## Application for Removal or Variation of a Condition following Grant of Planning Permission or Listed Building Consent

Thornhill Road

Two storey side extension, first floor side extension, part two storey, part single storey rear extension and conversion of garage to habitable use

22378/APP/2022/683

PROPOSED SIDE ELEVATION

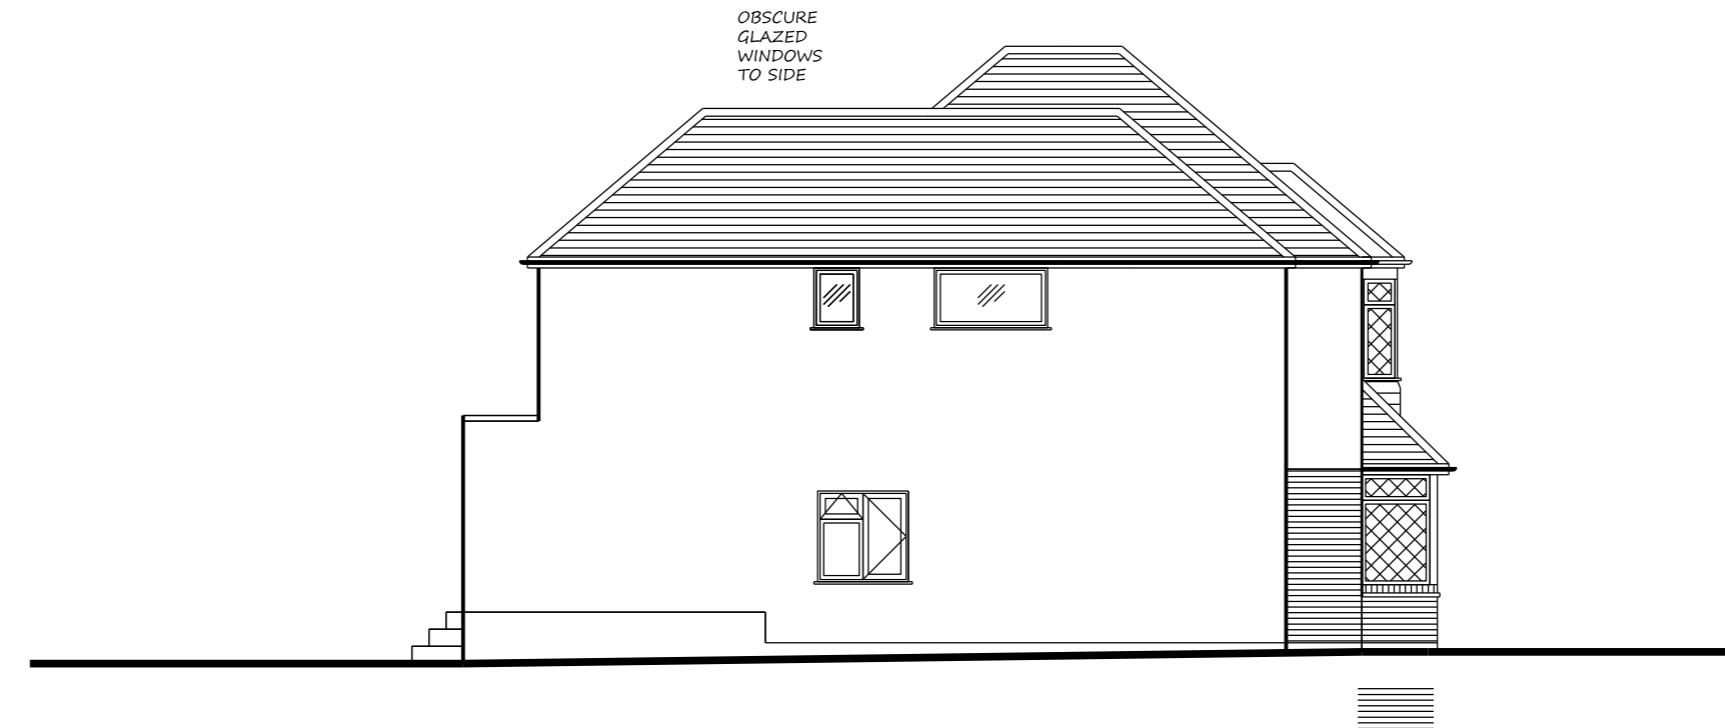
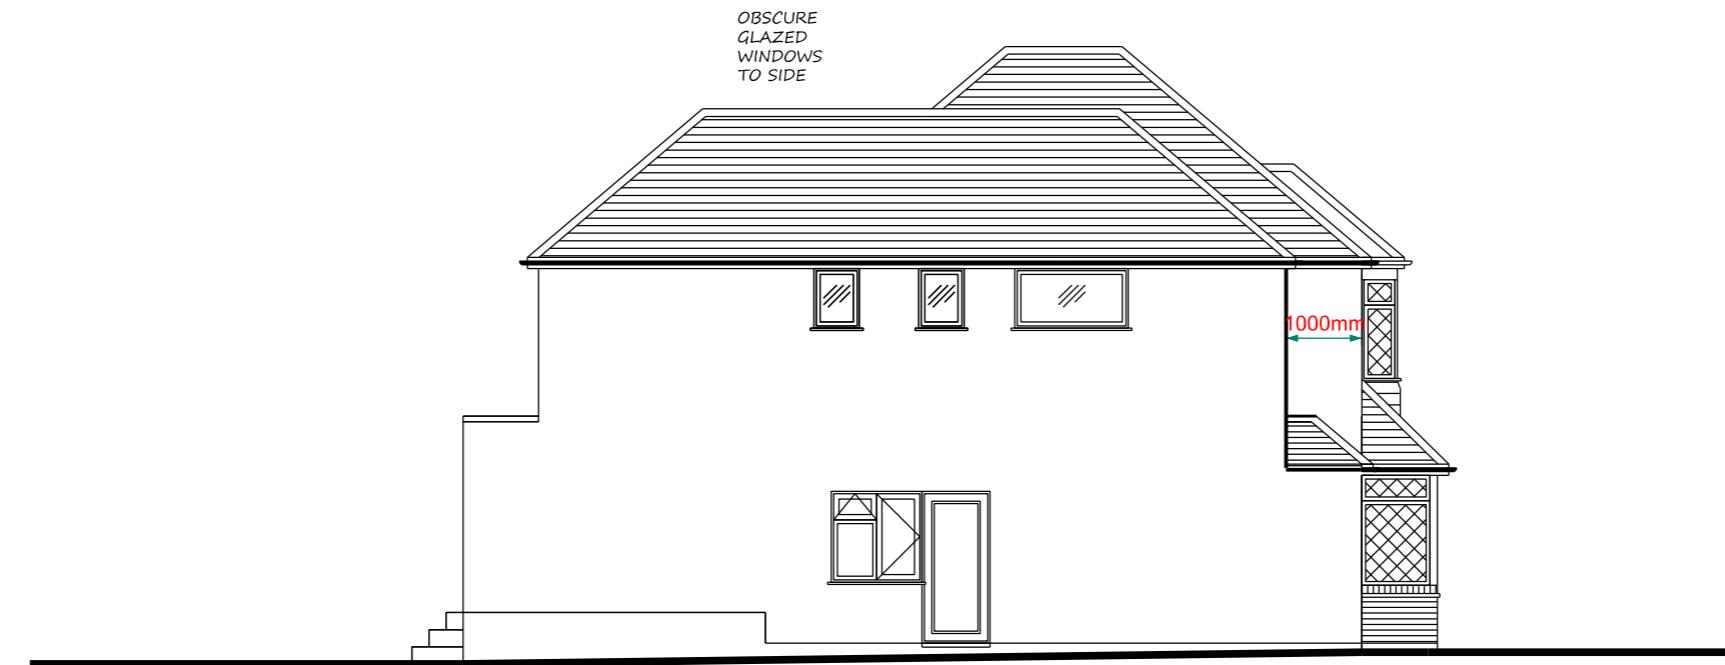
Condition 5: A single side window to be added to the ground floor side extension, facing No.63 (south-facing) to allow natural light into the room.

Condition 5: See attached updated plans which show the required changes to be implemented.

PROPOSED SIDE ELEVATION

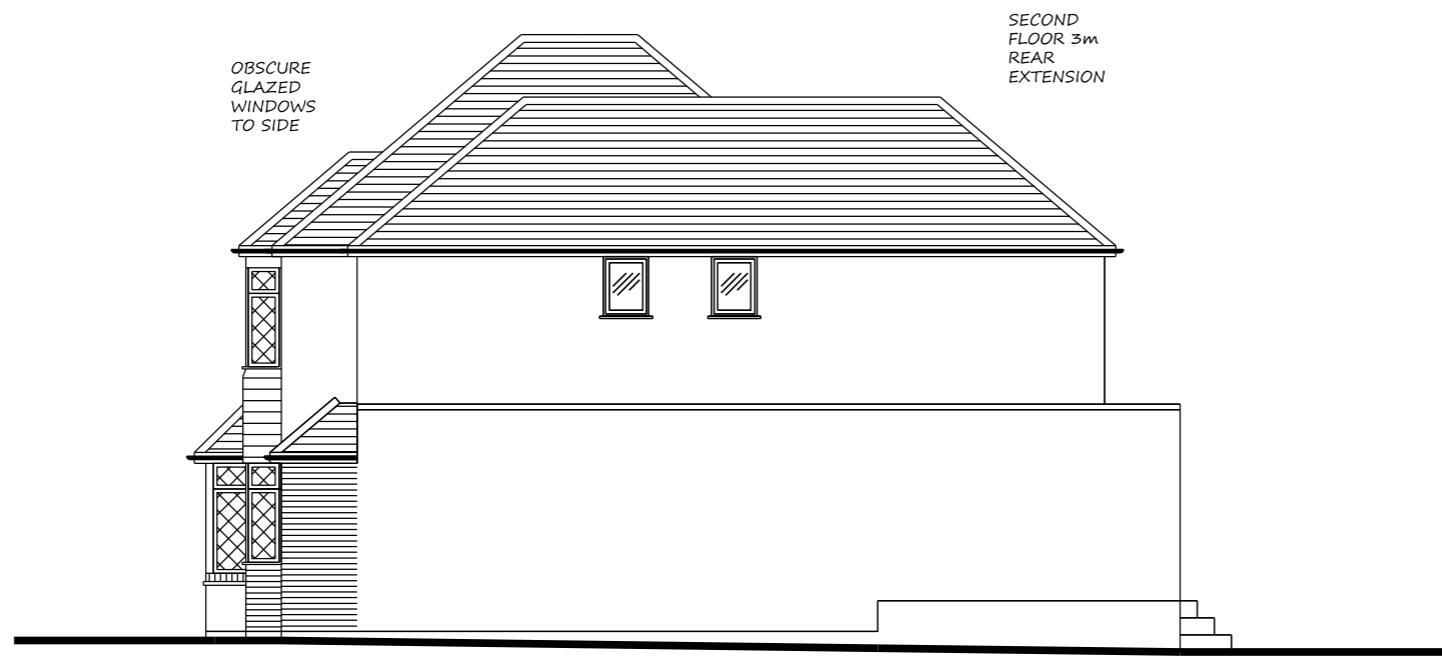
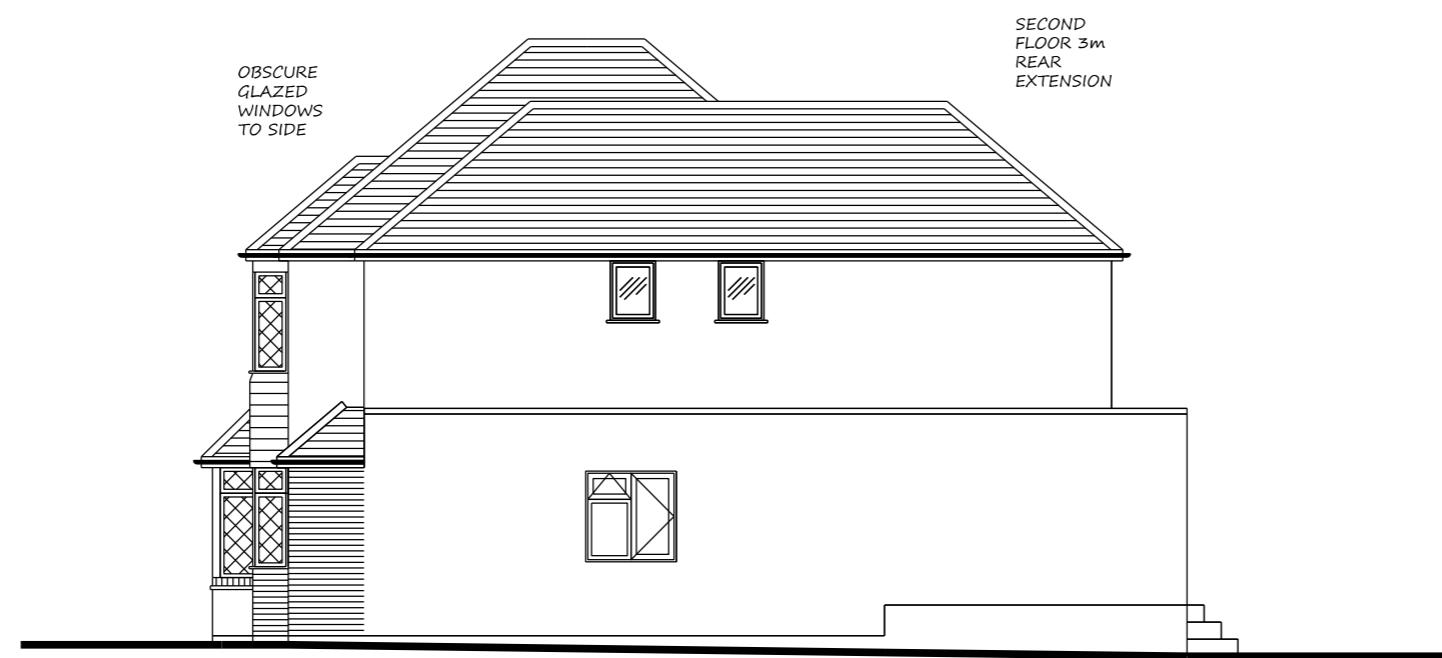
Condition 5: The side access door was mistakenly omitted from the side elevation plan, facing No.59 (north-facing), but was present in the ground floor plan. The side elevation plan has been corrected to show this door.

PROPOSED GROUND FLOOR PLAN

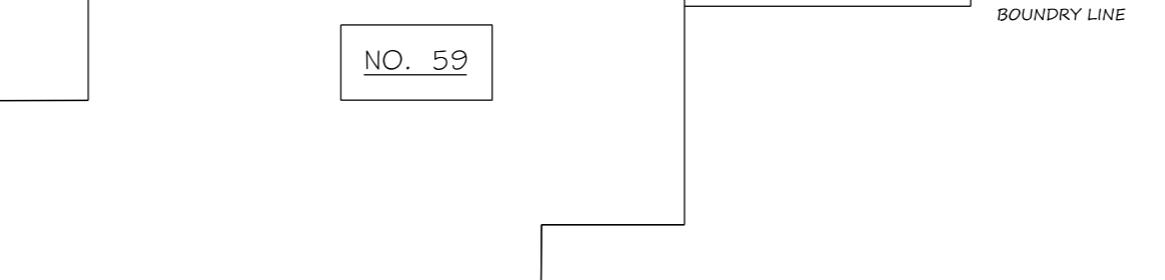
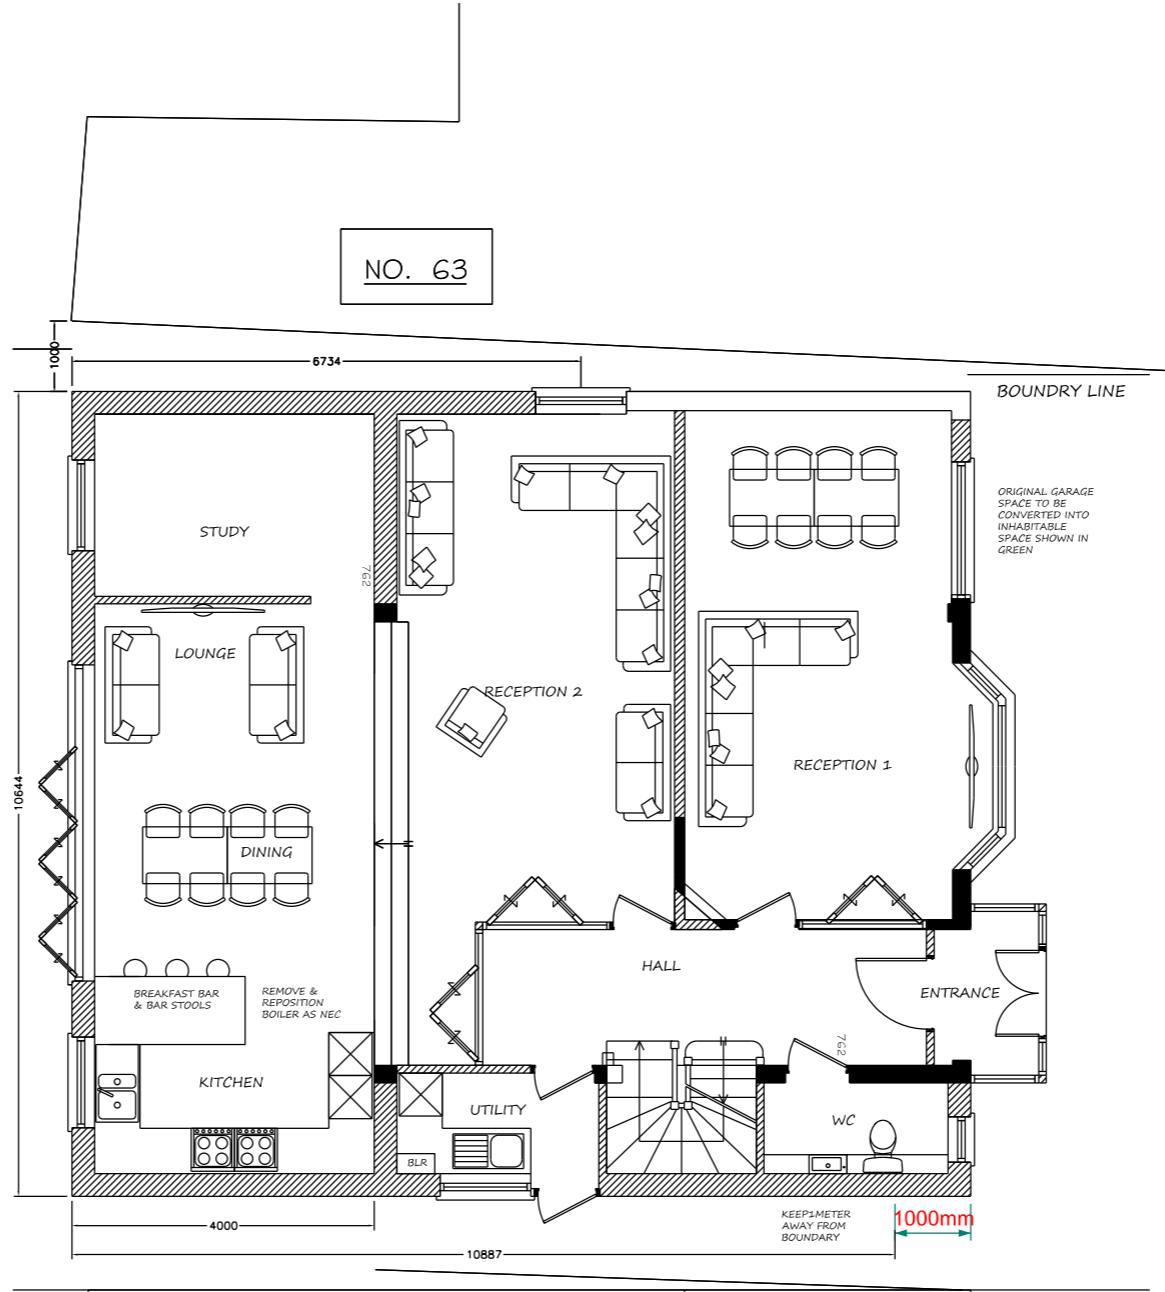
Condition 2: The agent made an error with the original application by setting the ground floor back by 1meter on the north facing side extension. There is already an existing solid/brick wall in line with the front wall of the house. The 1 meter setback is only required on the first floor.

Condition 2: See attached updated plans which show the required changes to be implemented.
